# CITY OF ALBUQUERQUE

July 30, 2019

**Re: Swim Labs Swim School**  
**8120 Ventura St. NE**  
**Traffic Circulation Layout**  
Engineer's/Architect's Stamp 07-27-2019 (C20D082)

1 Architectural Site Plan
Scale: 1"=30'-0"

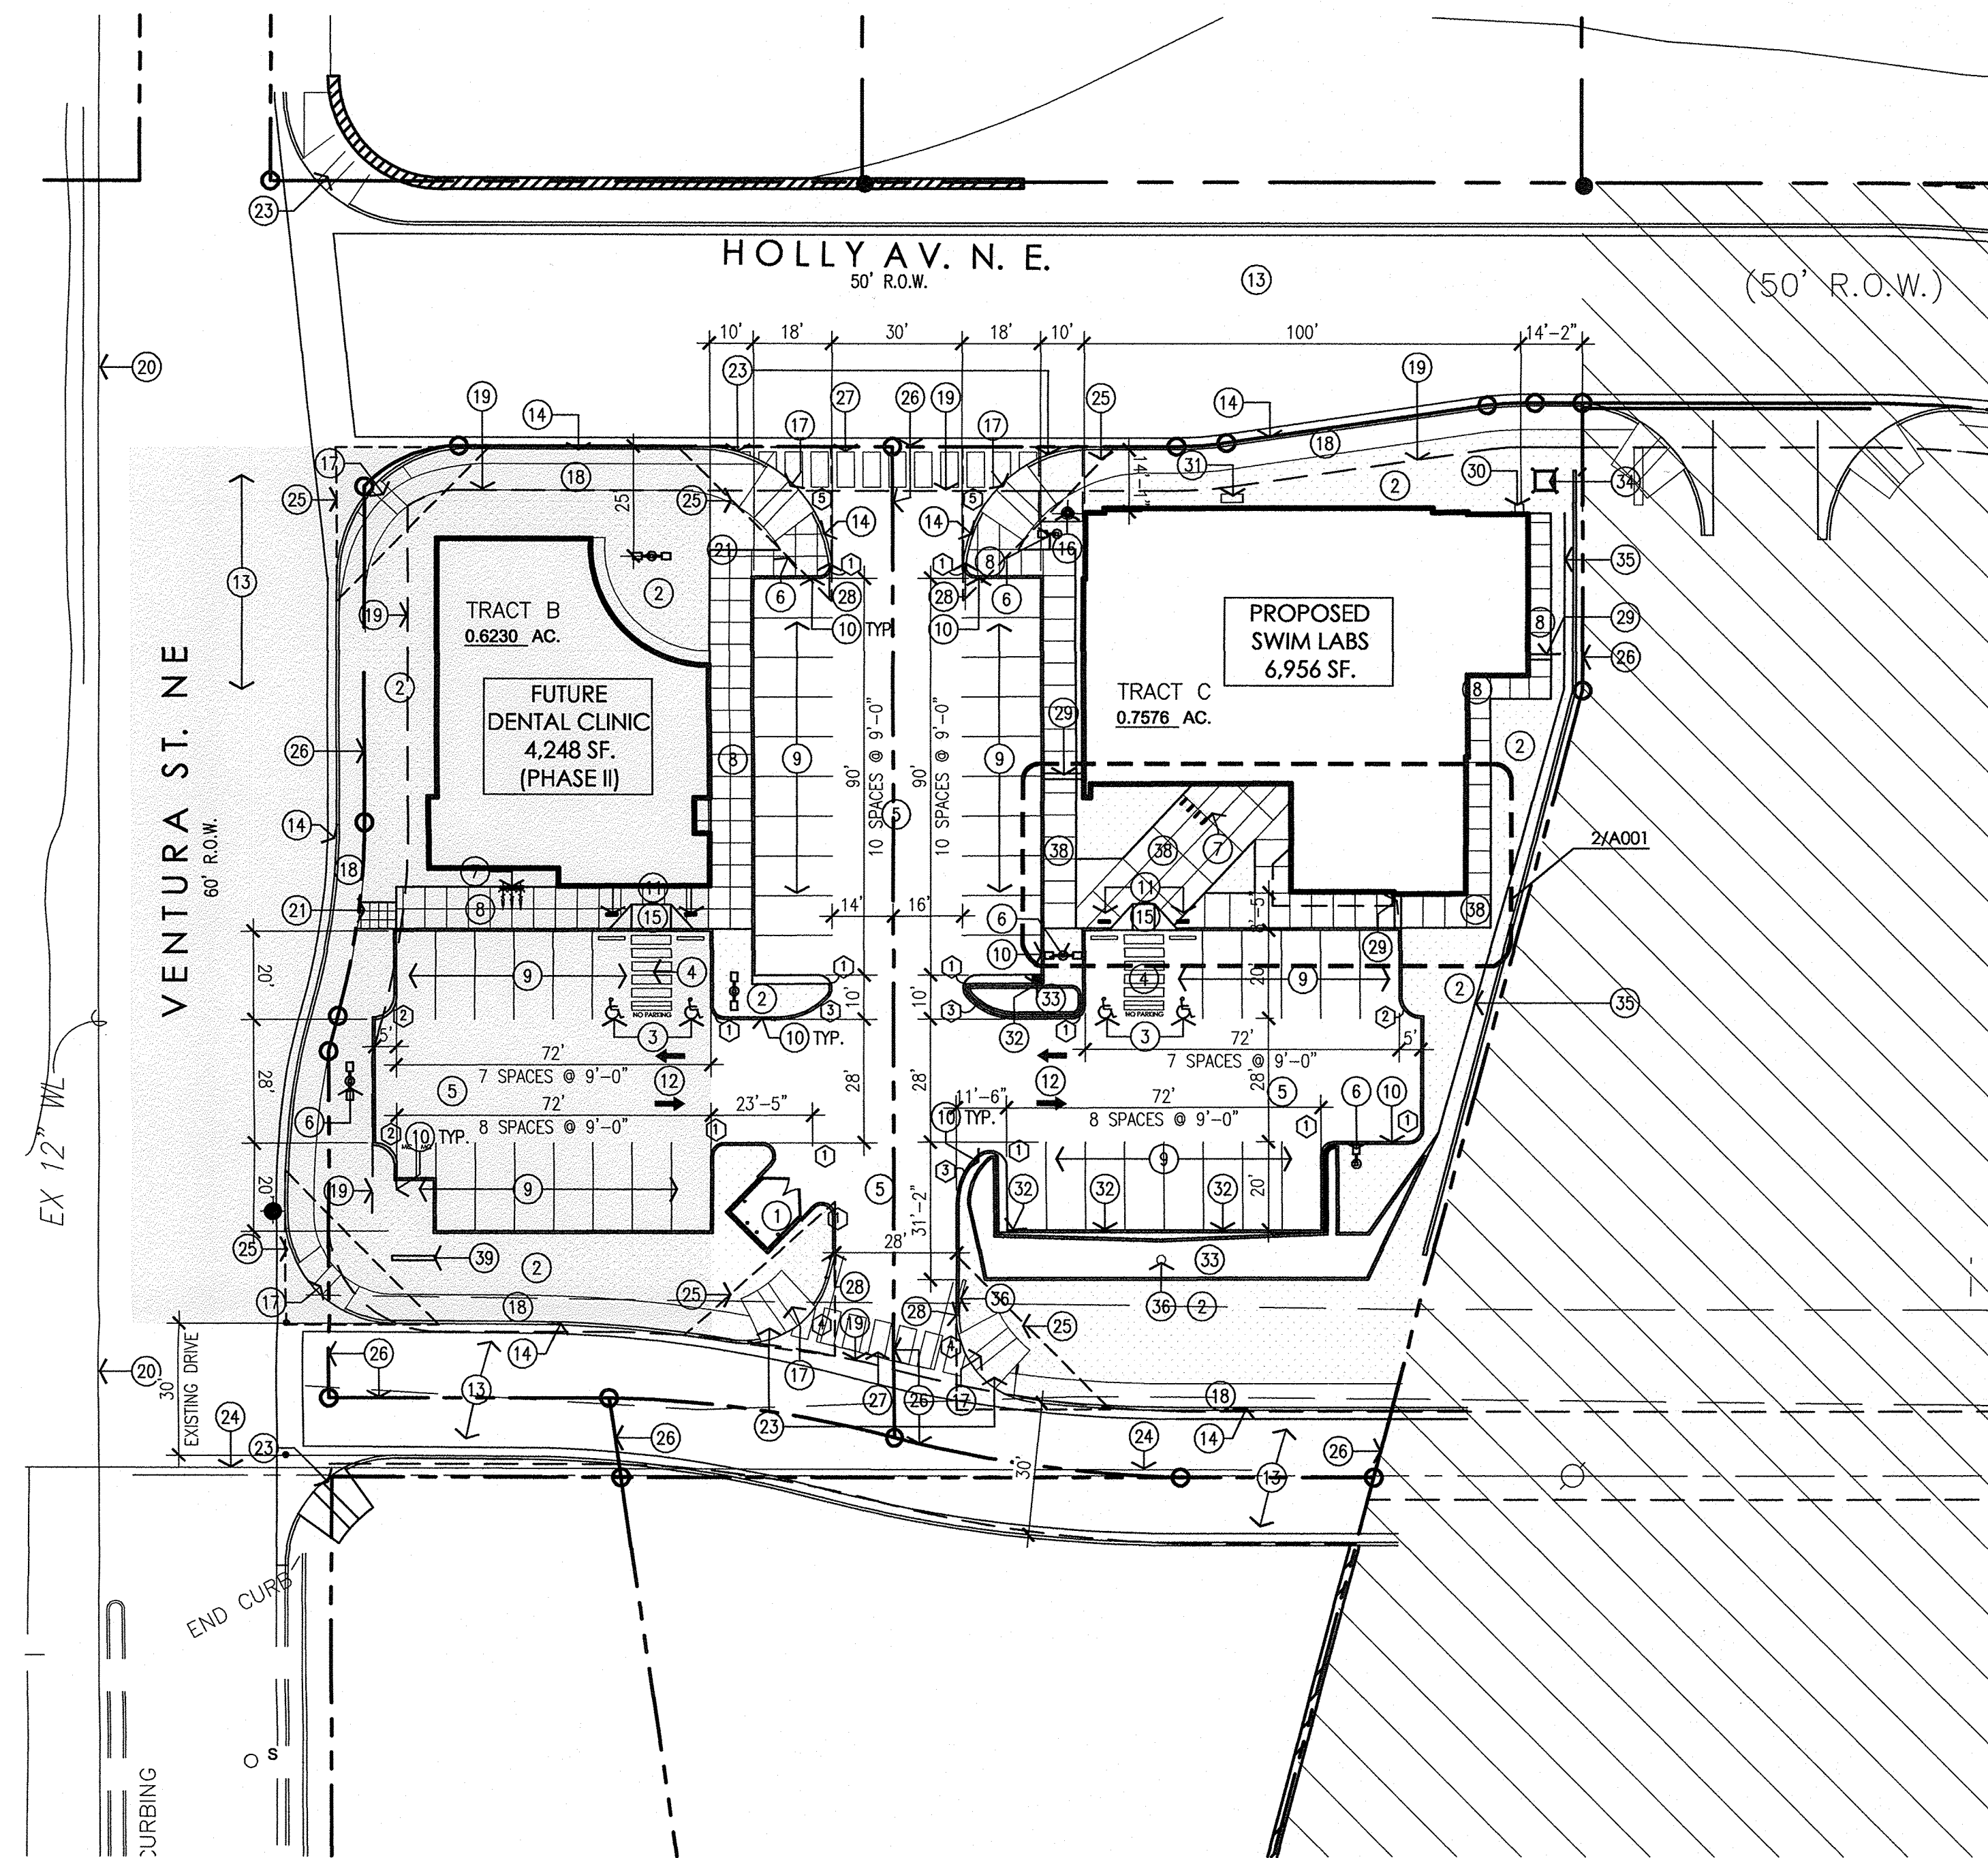
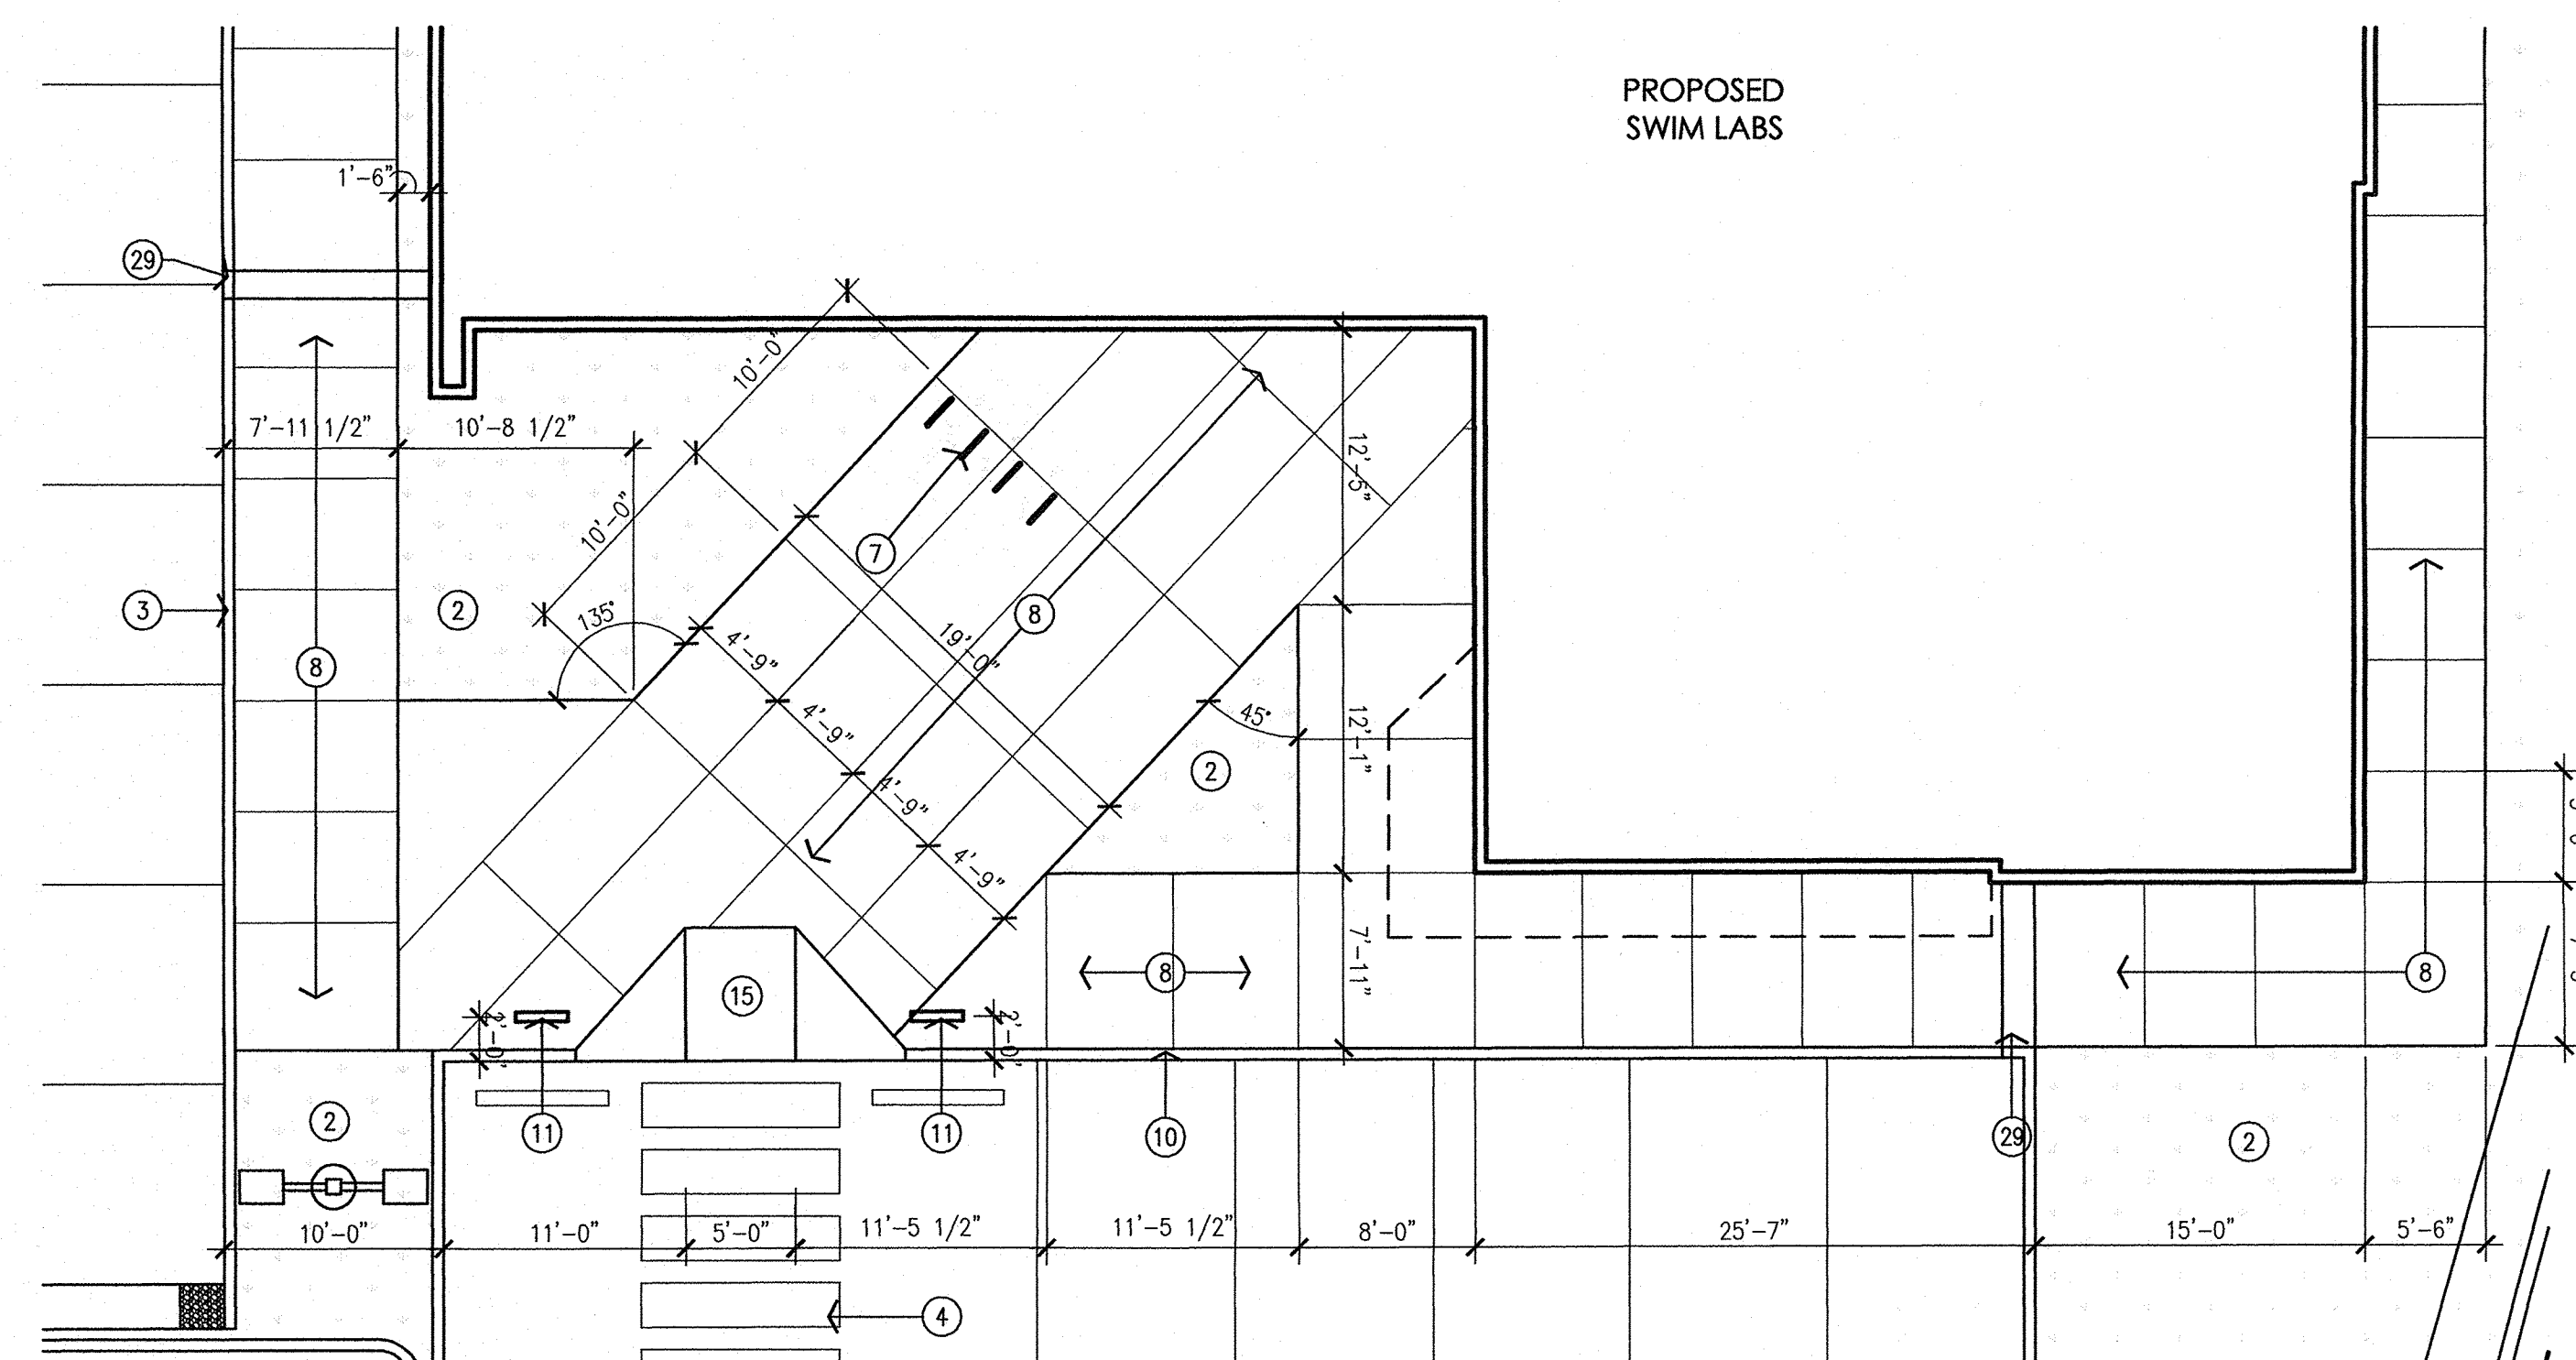
1. All bicycle racks shall be designed according to the following guidelines:
  - a. The rack shall be a minimum 30 inches tall and 18 inches wide.
  - b. The bicycle frame shall be supported horizontally at two or more places. Comb/toaster racks are not allowed.

- c. The rack shall be designed to support the bicycle in an upright position. See the IDO for additional information.
  - d. The rack allows varying bicycle frame sizes and styles to be attached.

- e. The user is not required to lift the bicycle onto the bicycle rack.
  - f. Each bicycle parking space is accessible without moving another bicycle.

2. Bicycle racks shall be sturdy and anchored to a concrete pad.
3. A 1-foot clear zone around the bicycle parking stall shall be provided.
4. Bicycle parking spaces shall be at least 6 feet long and 2 feet wide.

5. provide a copy of refuse approval.
6. Shared Site acces: driveways that straddle property lines, or are entirely on one propertybut are to be used by another property, shall have an access easement. Please include a copy of your shared access agreement with the adjacent property owner.
